**CITY OF ALBUQUERQUE
PLANNING DEPARTMENT
July 16, 2014
DRB Comments**

PROJECT # 1002478

RE: Blue Sky Business Park

D.R.B. Case No: 1002478	Date: 06/24/2015	Item No: #7
Zone Atlas Page: D-16	LOCATION: Lot 1, Blue Sky Business Park STREETS Jacs Lane between Las Lomas Dr. and Pueblo Road	
Request For: Preliminary & Final Plat Approval

# PLAT OF LOTS 1-A & 1-B BLUE SKY BUSINESS PARK SITUATE WITHIN PROJECTED SECTION 22, T.11N., R.3E., N.M.P.M. ELENA GALLEGOS GRANT CITY OF ALBUQUERQUE BERNALILLO COUNTY, NEW MEXICO MAY 2015

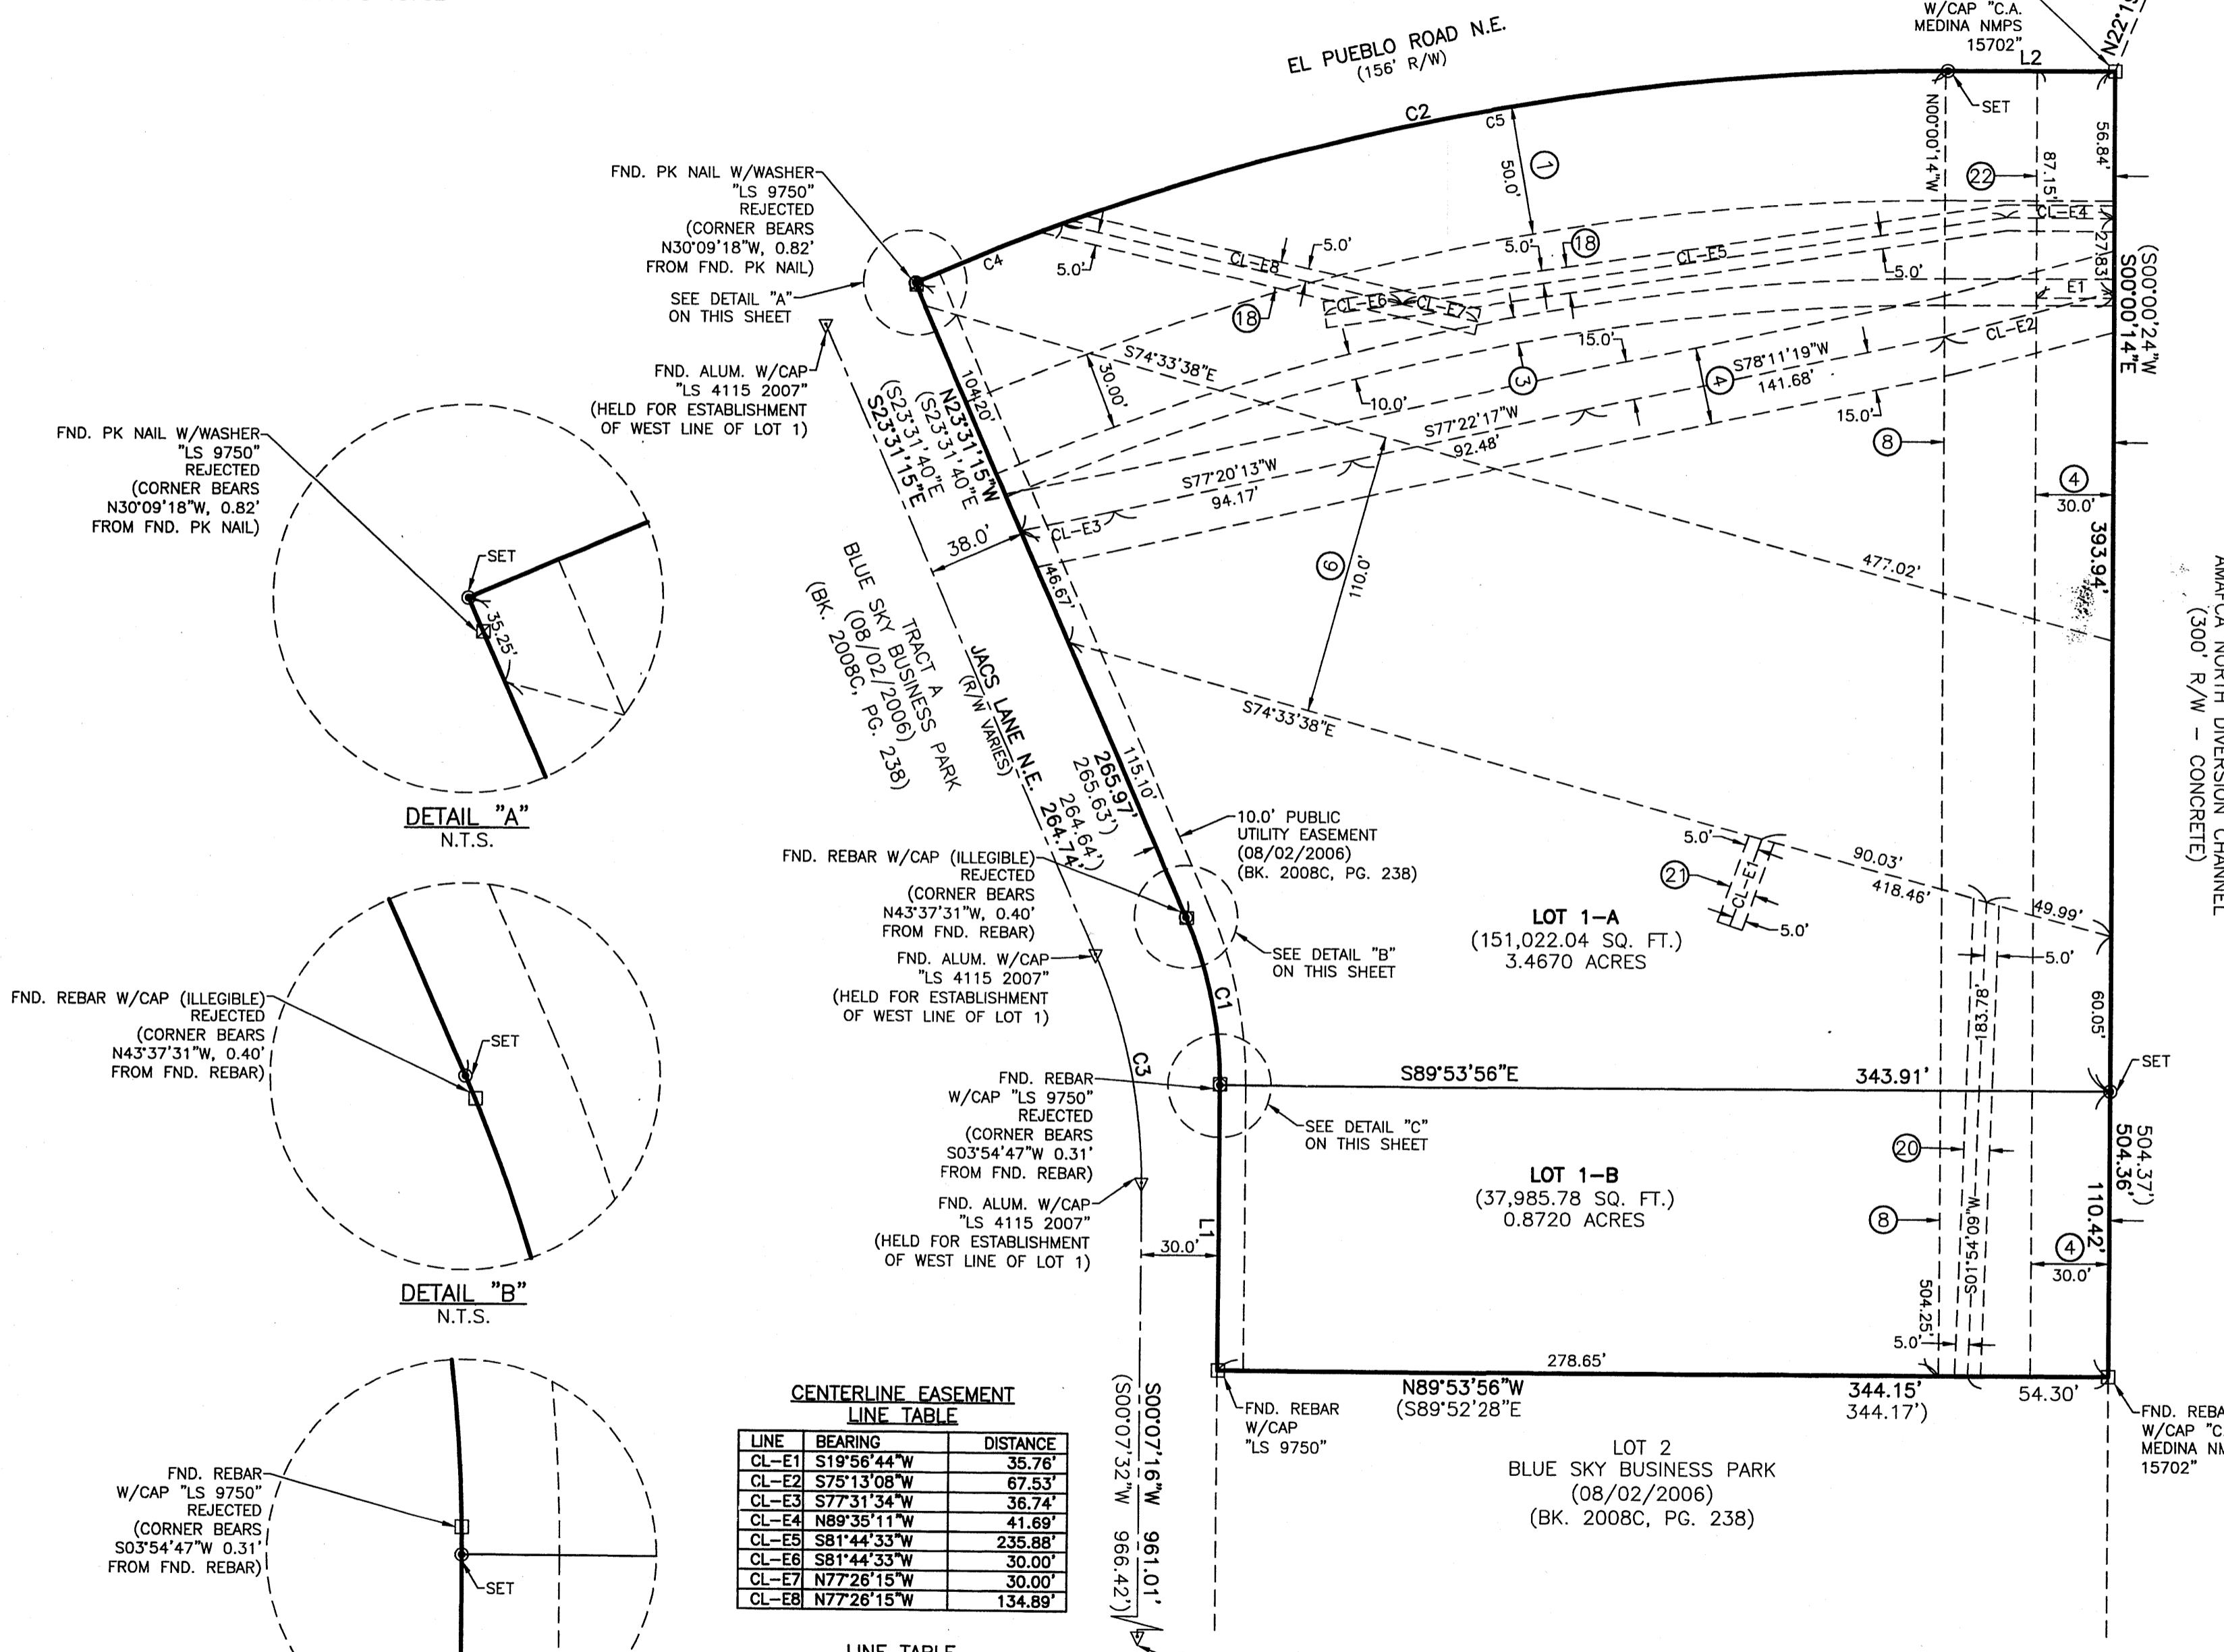
1. The extension of the 8" waterline and 8" sanitary sewer along Jacs La to cover the property frontage will be required. An infrastructure list will be required for these improvements.
